From: Julie Grieves on behalf of Planning.Responses
Sent: 26 October 2017 10:01
To: Planning Scanning
Subject: FW: Amended site layout - the Lillies Caravan park site, Yapton Road, Barnham

Subject: Amended site layout - the Lillies Caravan park site, Yapton Road, Barnham

scheme: The Lillies, Yapton Rd
Barnham
client: Matthew Homes
drawing: Landscape Proposals
date: April 2017
scale: 1:200@A1
drawing no: MAT21212 11A sheet 2
drawn: AE checked: DKM

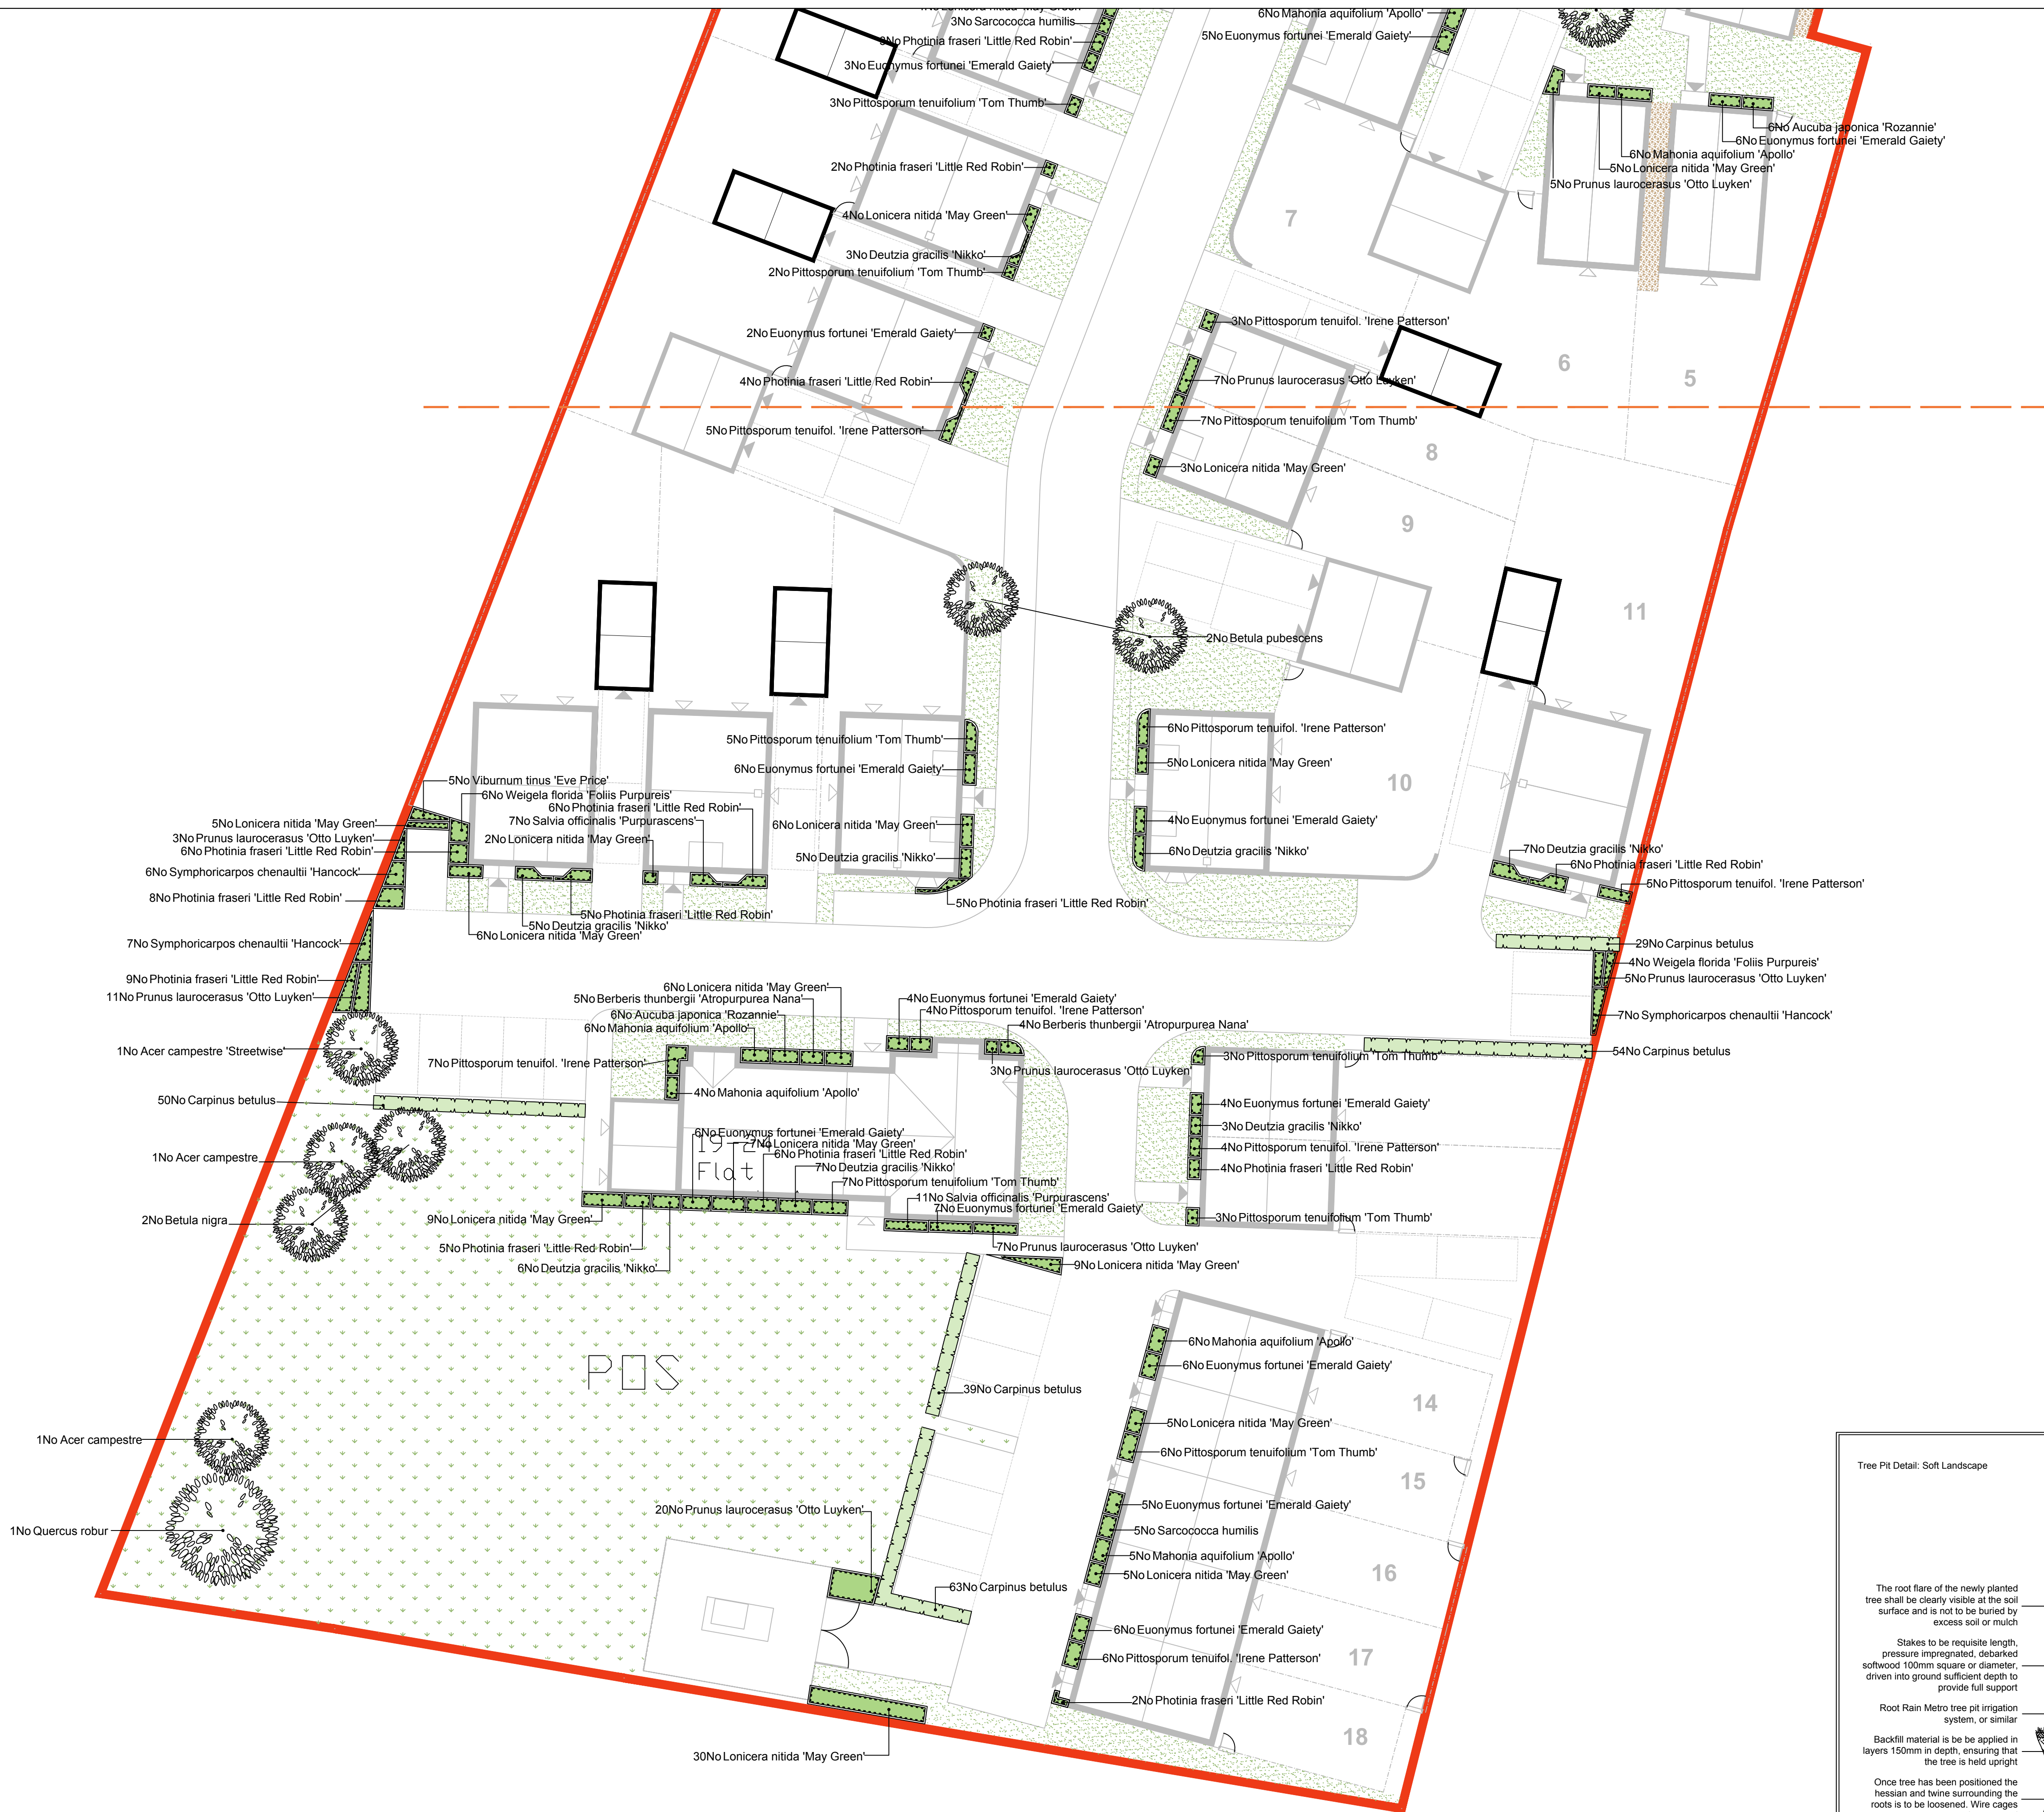
The outline plans showed tree planting to this open space area, again trees would not thrive if this area were to hold water.

Flat Block A
Floor Plans & Elevations
Plots 19-24

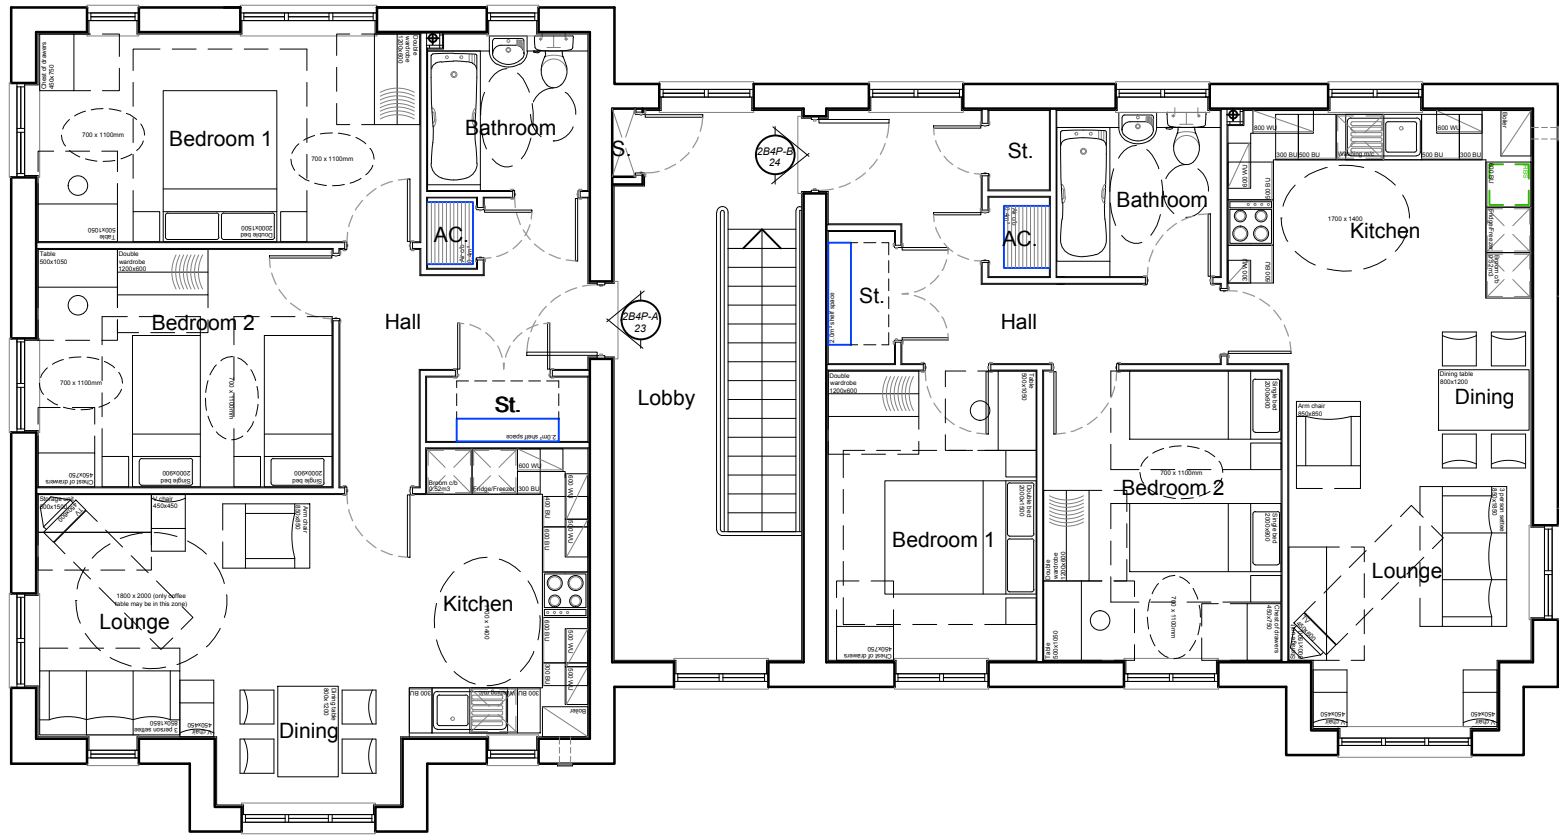
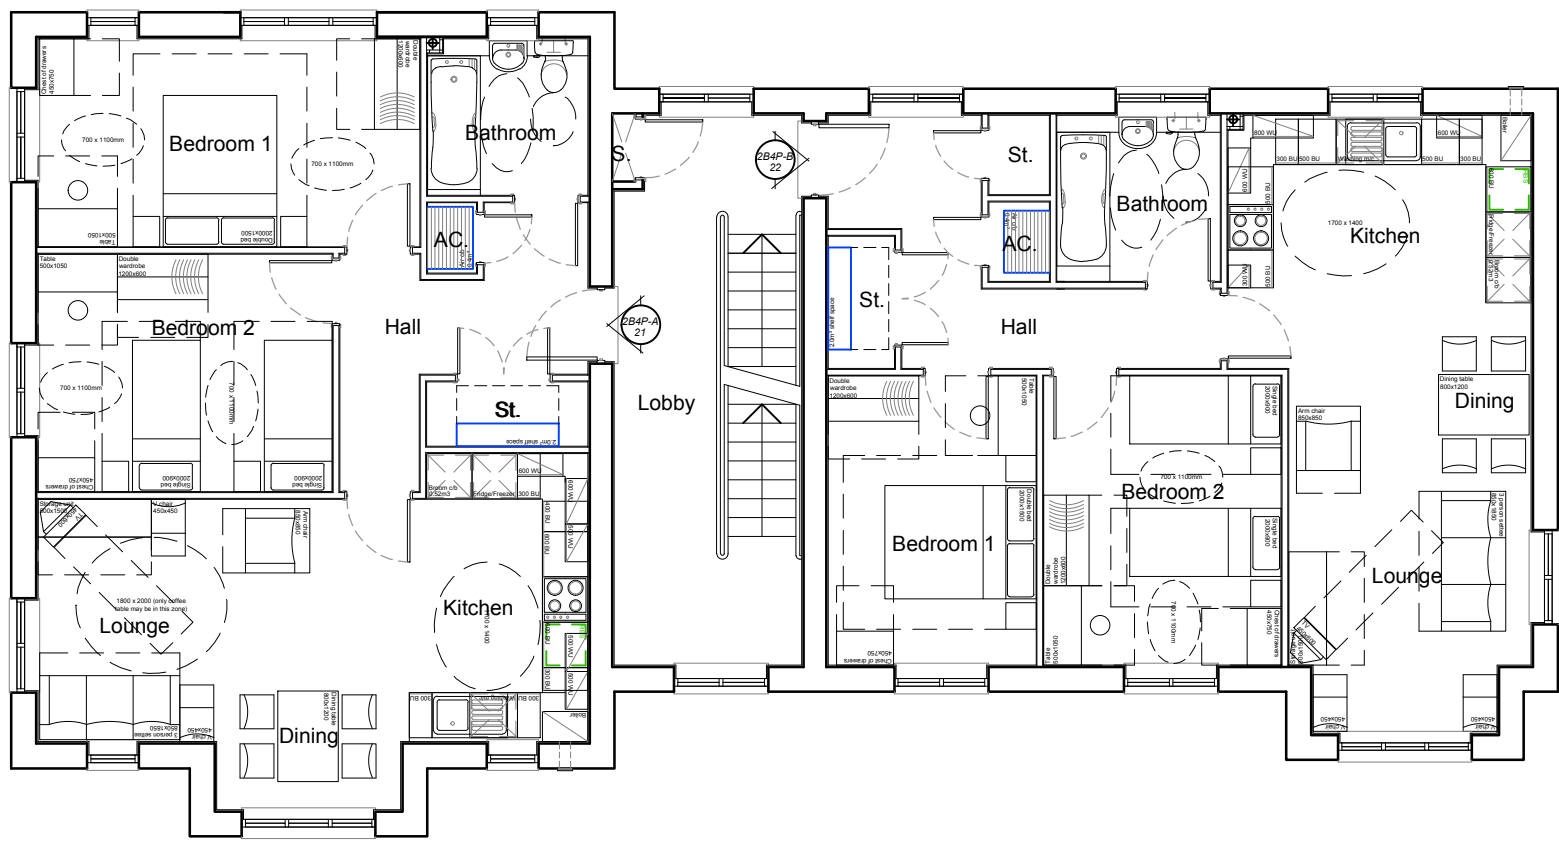
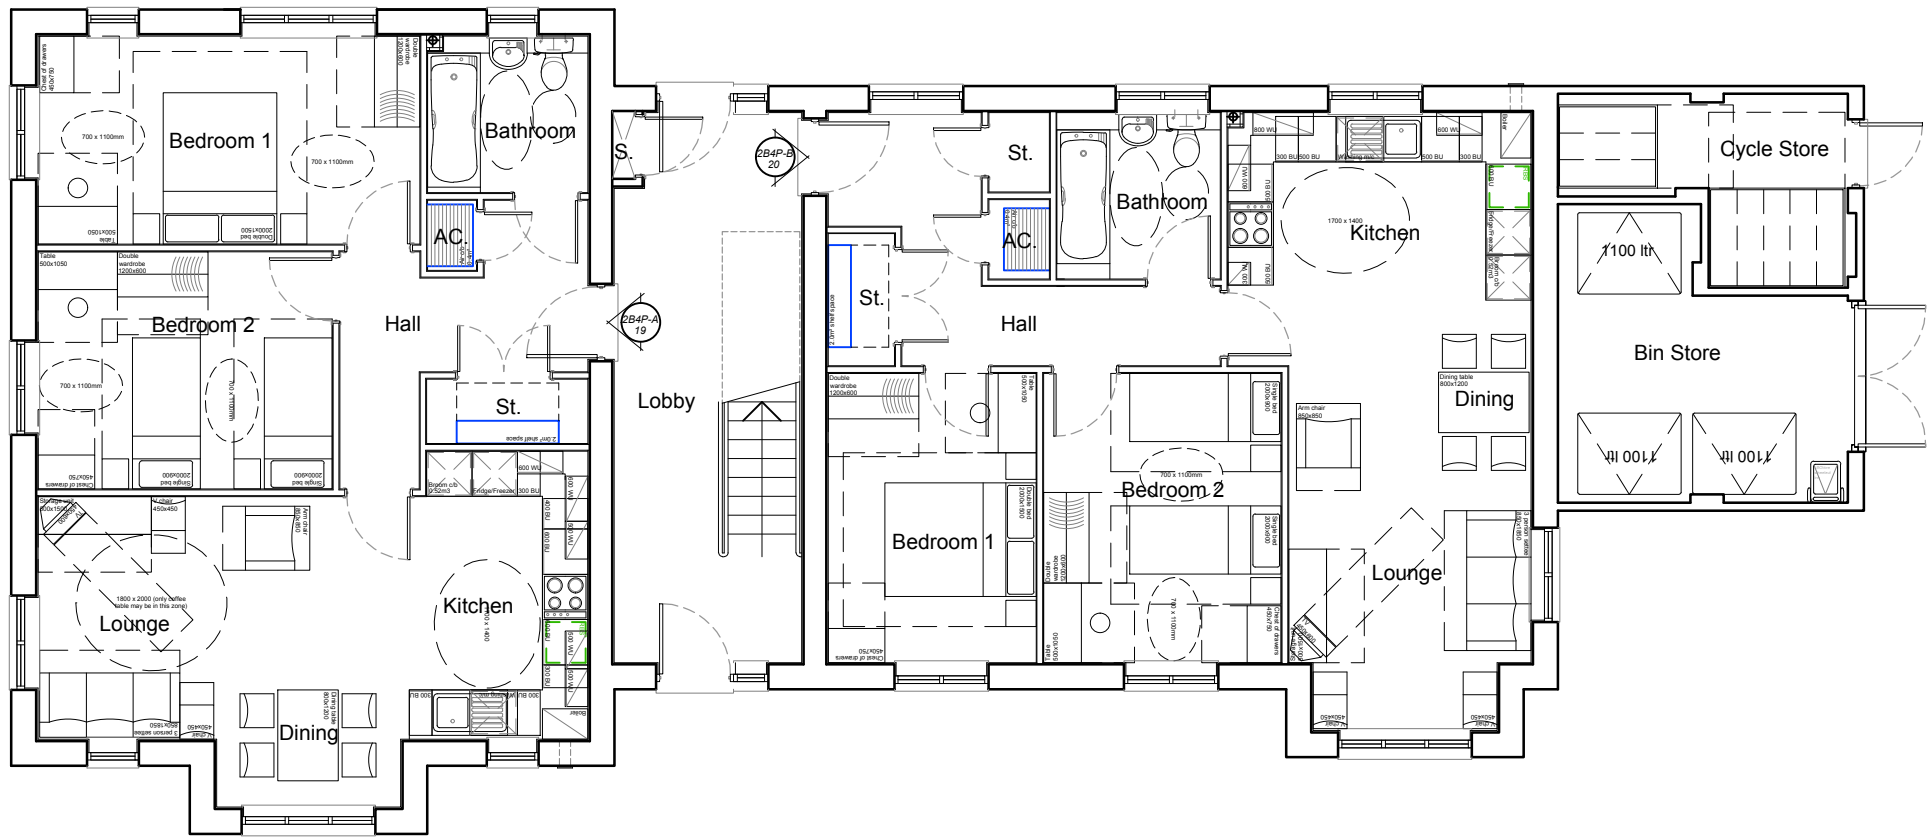
The now indicated attenuation basin to the centre of the POS is also of concern and would require clarification of whether this will be a standing water body? And what element of the year this will be the case? This area only depletes the POS as it would then not be classed as usable POS? and my concern also is regarding proximity of this in relation to Flat Block A 19-24 which should be raised and addressed.

The flat block is deemed ok location wise to the basin, no issues from the ADC Drainage consultant.

TITLE YAPTON ROAD
BARNHAM
DETAILS SUDS CROSS SECTION
DETAIL 2

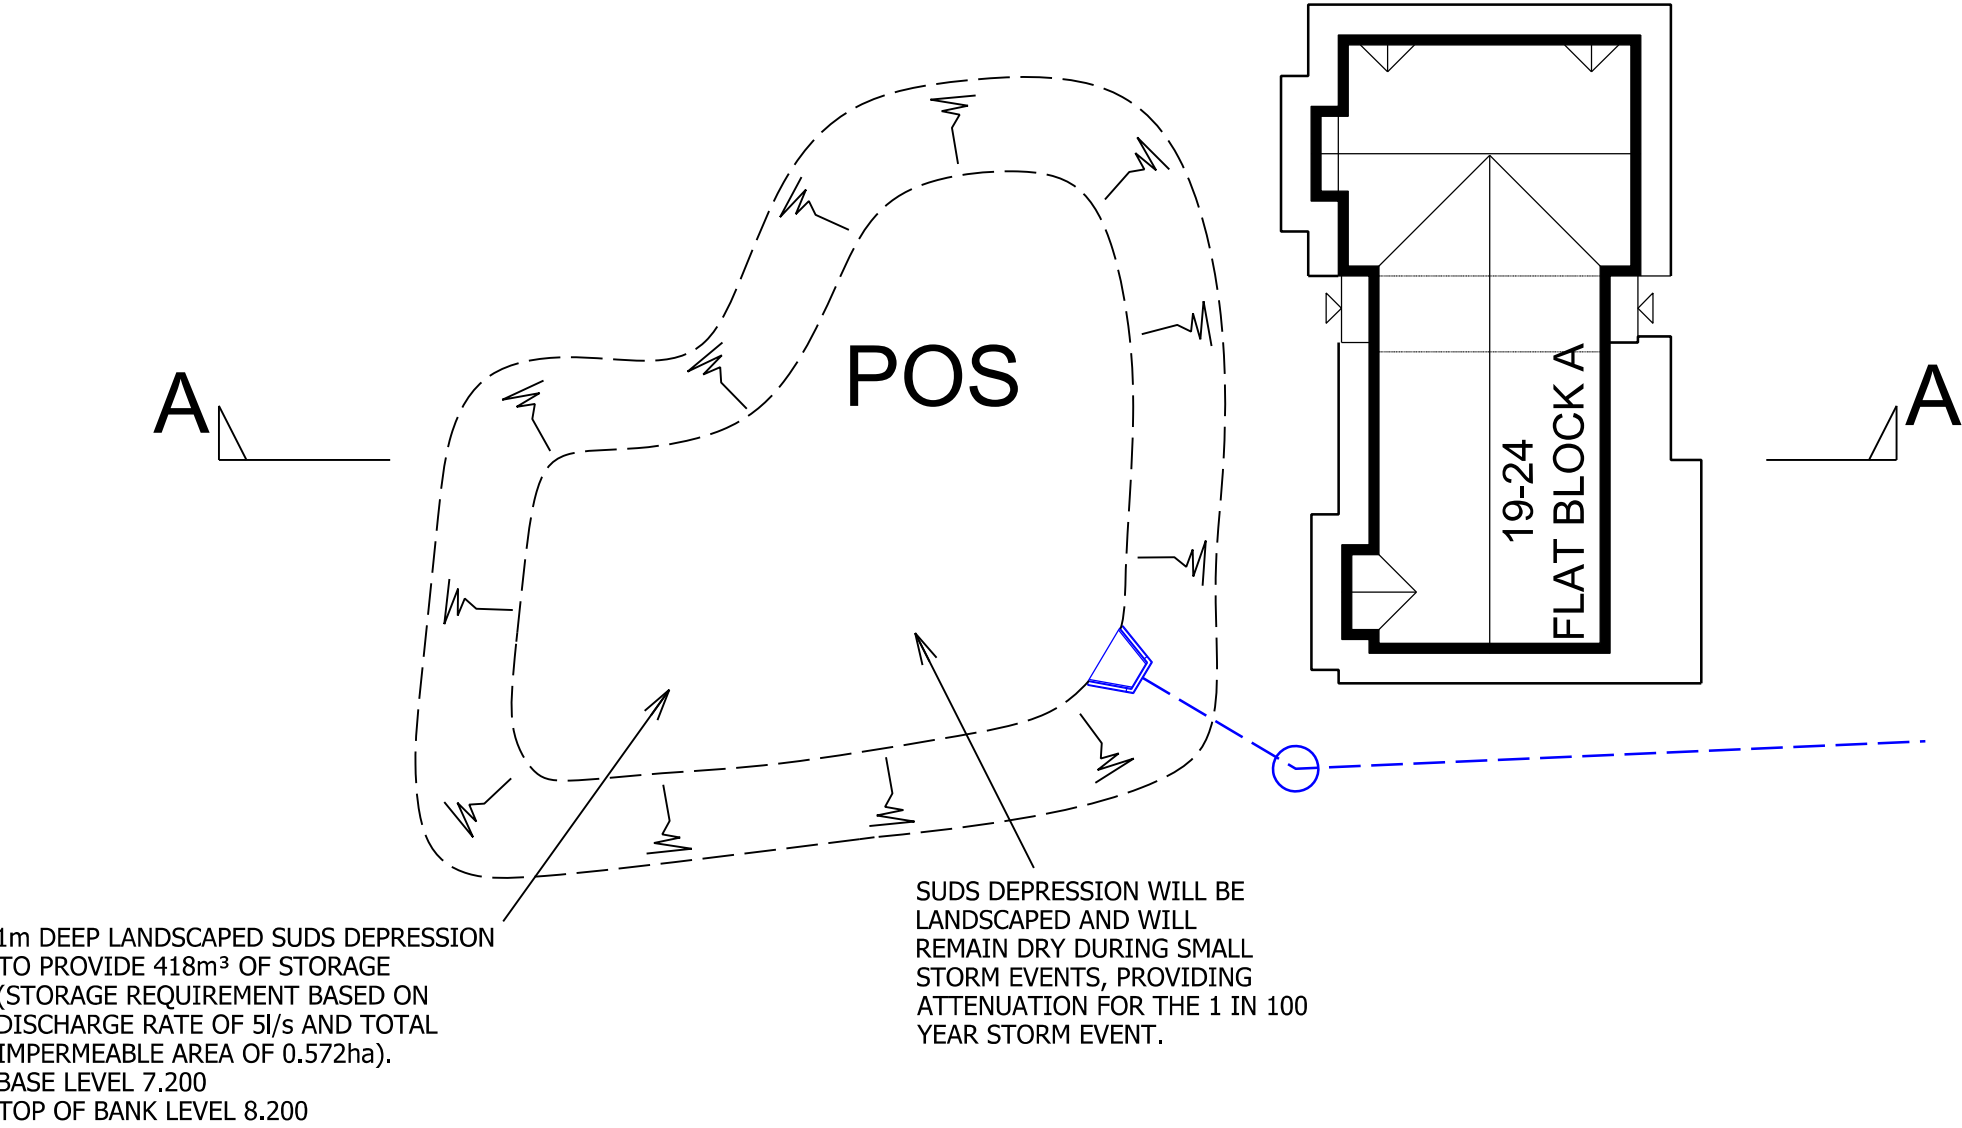
The POS area now confirmed in m2 falls significantly short of our SPG for open space requirement. This is even before what is proposed is considered as useable or un-usable which now as it is shown as the majority forming an attenuation basin, would not be classified as usable. The prospect of heavy rain being the determining factor to usability this would give no certainty as to availability year round. If this is the primary Open Space within this proposal for children to play, would it be deemed acceptable to be proposing that they play in a potential waterbody?

The basin is not permanently wet and would only have water in if there was a very heavy rainfall thus this area would then be feasible use as POS.
